**From:** [Arden Thomas](#)  
**To:** [Jeremiah Cromie](#)  
**Cc:** [Samantha Cox](#)  
**Subject:** RE: SX-22-00019 Jenkins - Request for comment  
**Date:** Friday, October 14, 2022 4:19:55 PM  
**Attachments:** [image001.png](#)

## FLOOD COMMENTS

Please review the Shoreline Exemption Permit applied for by Jody Joldersma & Matthew Jenkins for an emergency temporary erosion control measures including root wads and rocks in Gold Creek to prevent further erosion to an existing house. As this is being applied for under an emergency shoreline exemption and emergency SEPA, please have all comments back to me no later than **5p October 14, 2022**. Links to the file materials can be found below. If you believe other people/agencies need to be included please let me know ASAP.

2022 Proposed Plan
(Pin down root wads with large rocks along shore toe then reassess and follow up next year)

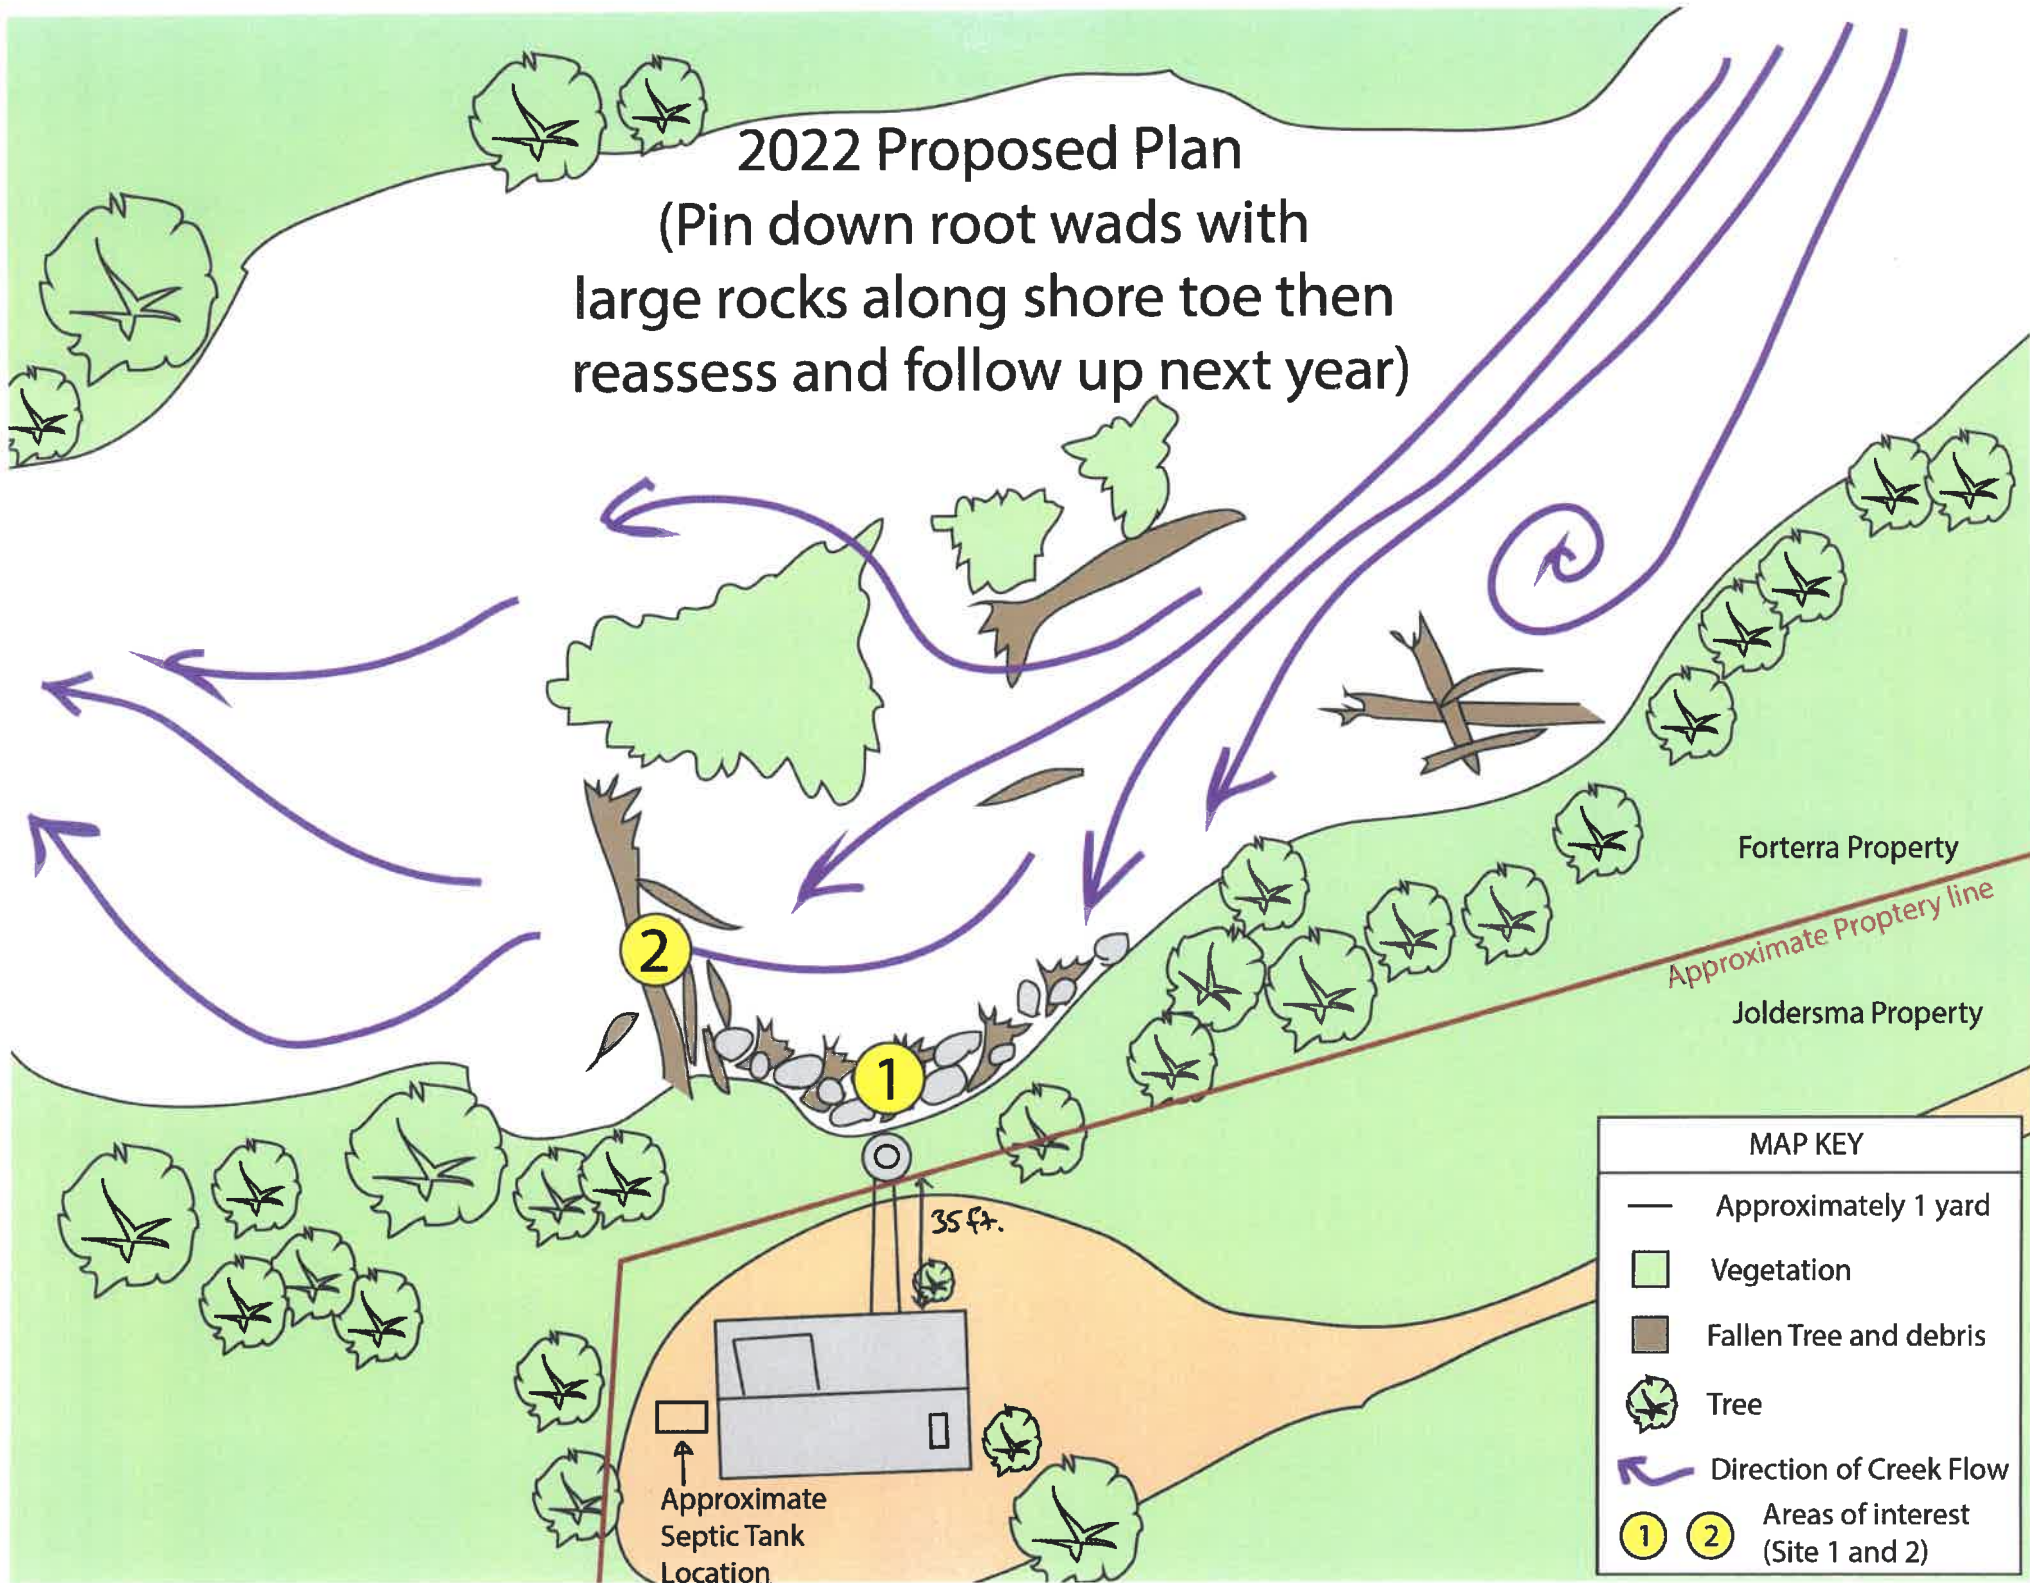
The FEMA mapped floodplain is not aligned with the active river channel at this location. Per KCC 14.08.150, when there is a conflict between the mapped boundary and field conditions, the floodplain administrator can make interpretations about the exact location of the floodplain boundaries. The proposed project location is determined to be within the 100-year floodplain for Gold Creek.

Kittitas County Code Chapter 14.08 (Flood Damage Prevention) requires adequate anchoring (KCC 14.08.190) and that fill and grade in the floodplain does increase upstream or downstream hazards (14.08.315). No documentation has been provided to evaluate whether these standards have been met. There is risk that if size, location, and placement of material is not appropriate for site hydraulics, the addition of wood and rock may increase, rather than decrease bank erosion. Given this risk, for similar projects we have told potential applicants that they need to provide technical documentation supporting the basis of design. Additionally, our code requires compensatory mitigation for fill placed within the 100-year floodplain.

KCC 14.8.105 requires that all necessary federal, state, or governmental approvals are obtained. ESA-listed bull trout are present at Gold Creek. It is not clear from the proposal if in-water work may be authorized, which may have direct impacts to bull trout.
